Our reference: EF13/3577: DOC14/24915-1
Contact: Stefan Press 02 6229 7002

11 March 2014

**RE: Shoalhaven Starches Pty Ltd - Proposal for minor modification to the DDG Pelletising Plant –
Section 75W EP&A Act - MP06_0228 –
Lot 62 DP 1078788, Bolong Rd, Bomaderry NSW.**

PRO
GAS-
CO-GE

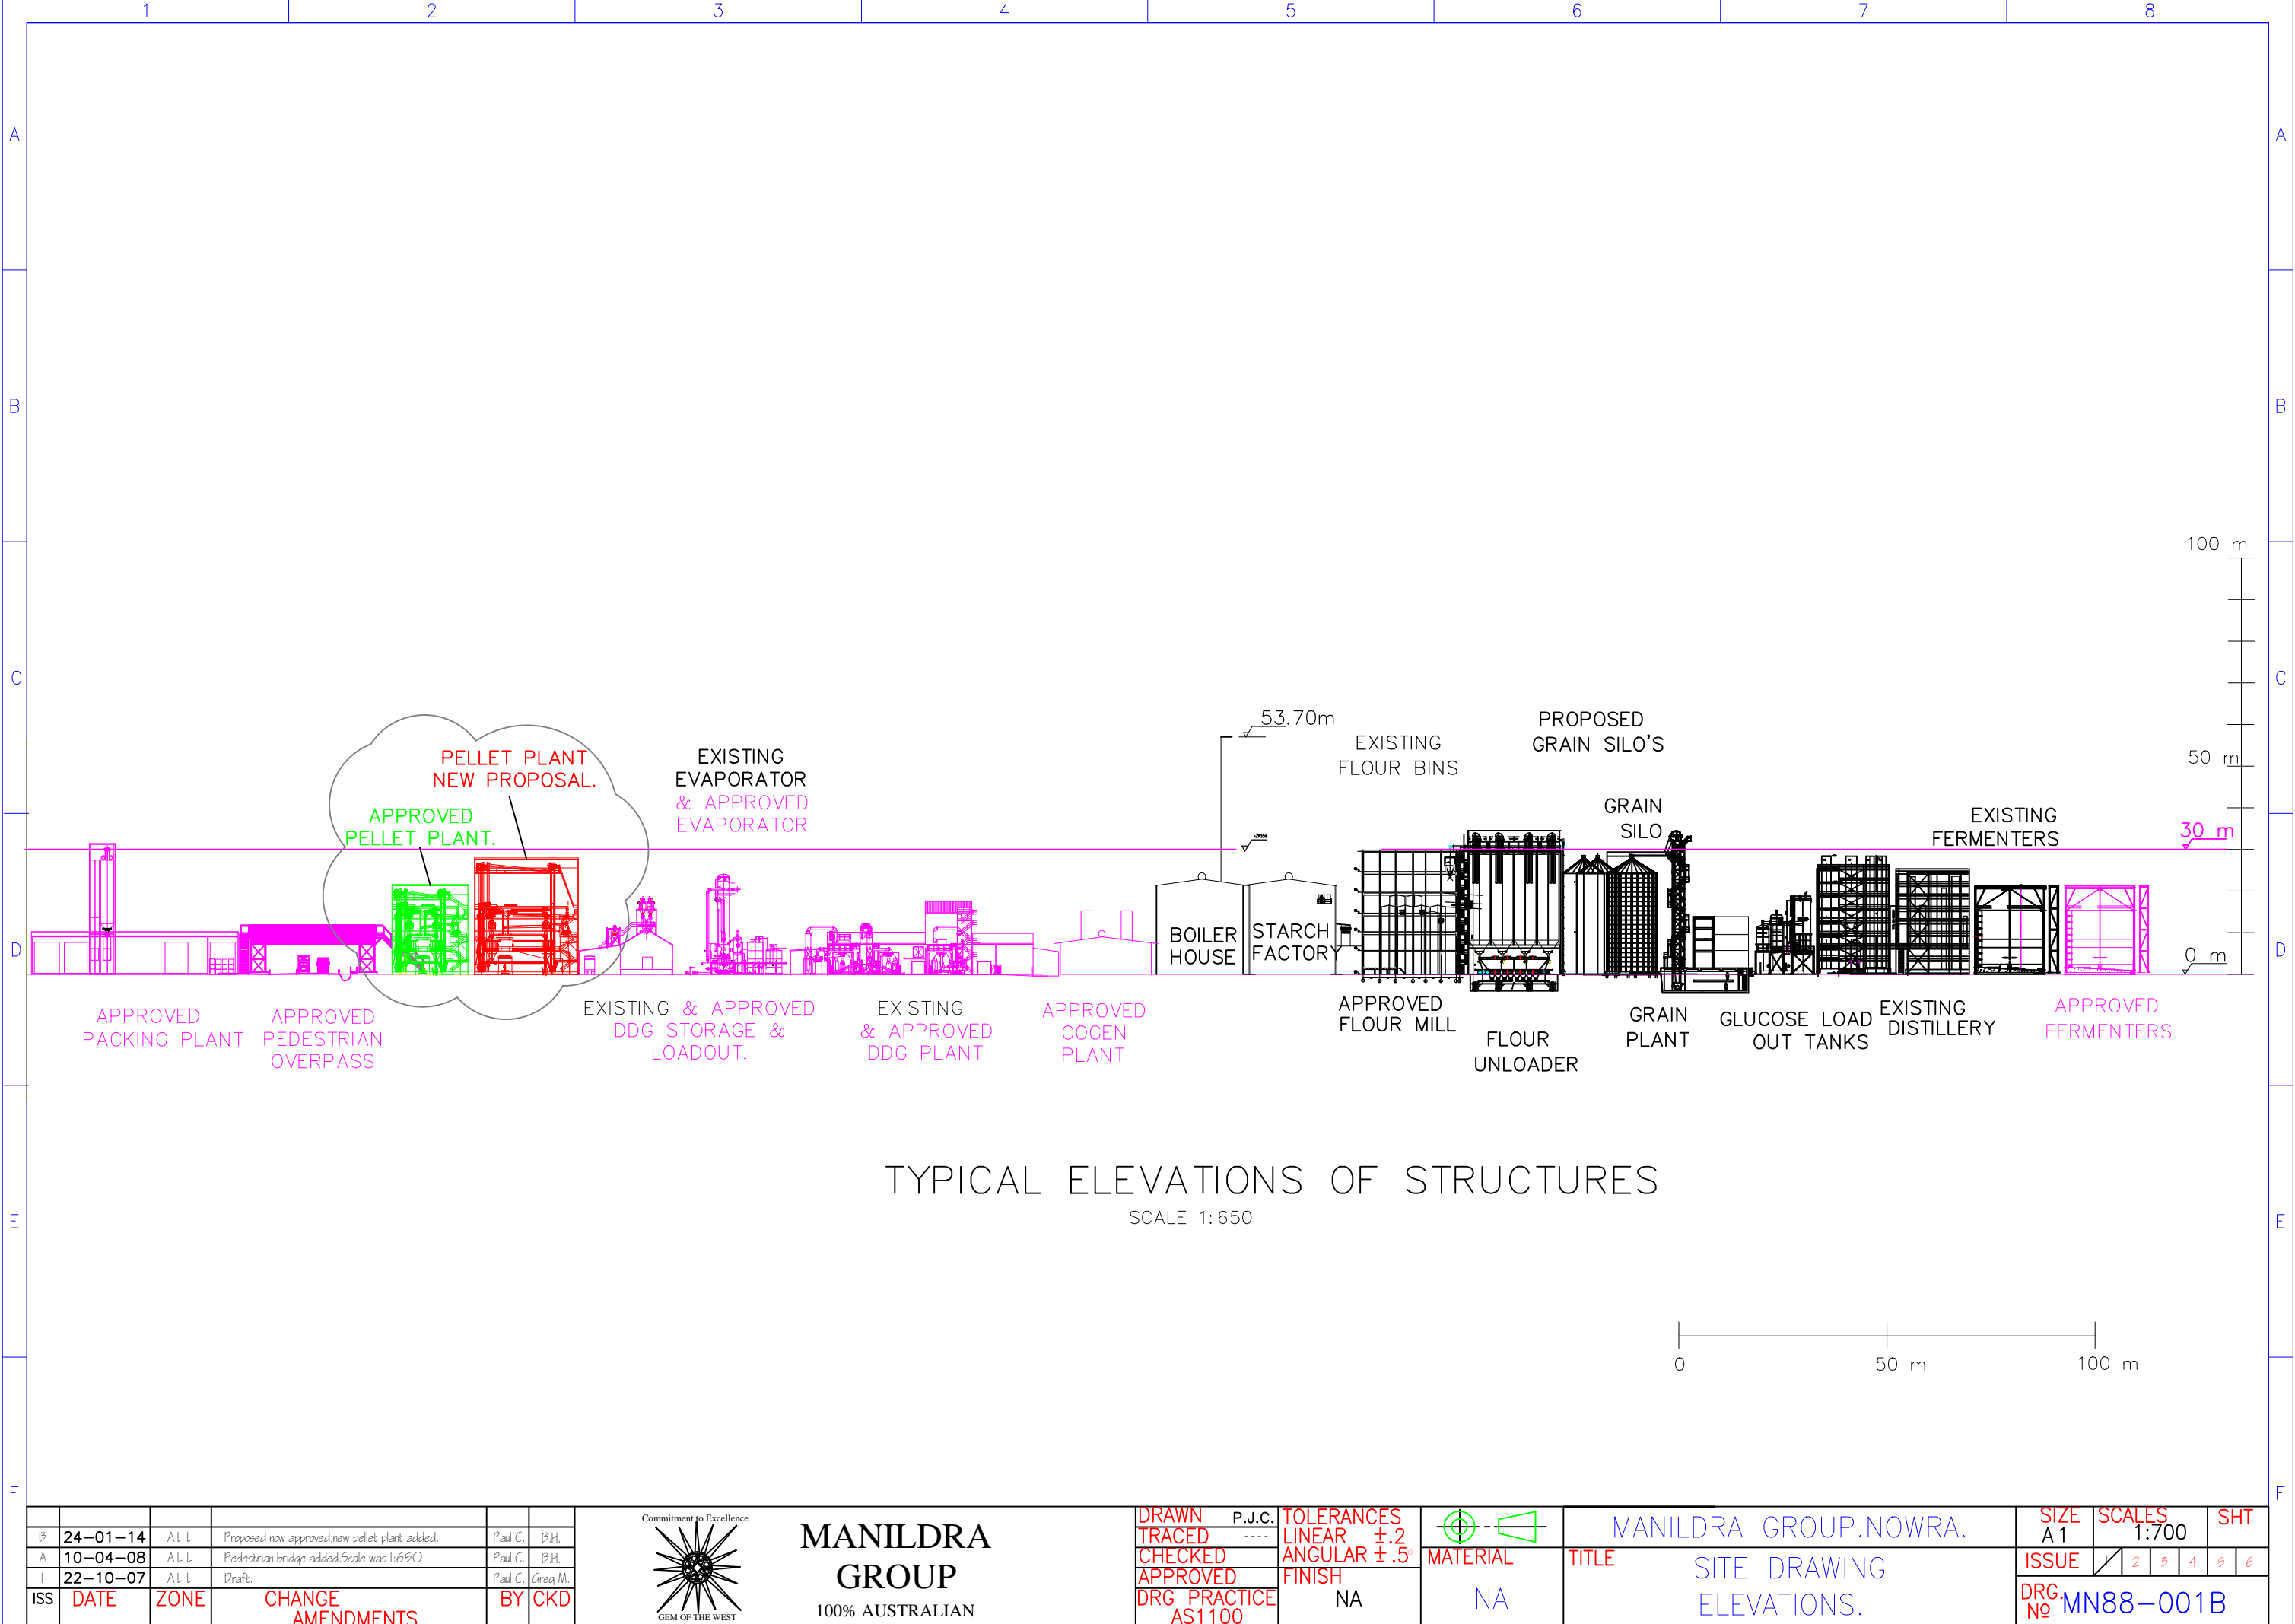
The EPA has reviewed the Environmental Assessment provided to support the proposed modification. The changes in location, size and height above ground level to the originally proposed development are consistent with the original environmental impacts identified in the Environmental Assessment for the development.

The EPA notes the Environmental Assessment states that the air emissions from the proposed DDG pelletising plant are to be conveyed to the existing biofilters for odour treatment. The EPA recommends that prior to any approval for this modification that Shoalhaven Starches demonstrates there is sufficient capacity in the biofilters to effectively treat the additional odorous air streams from the DDG pelletising plant, or whether additional odour treatment capacity will be required.
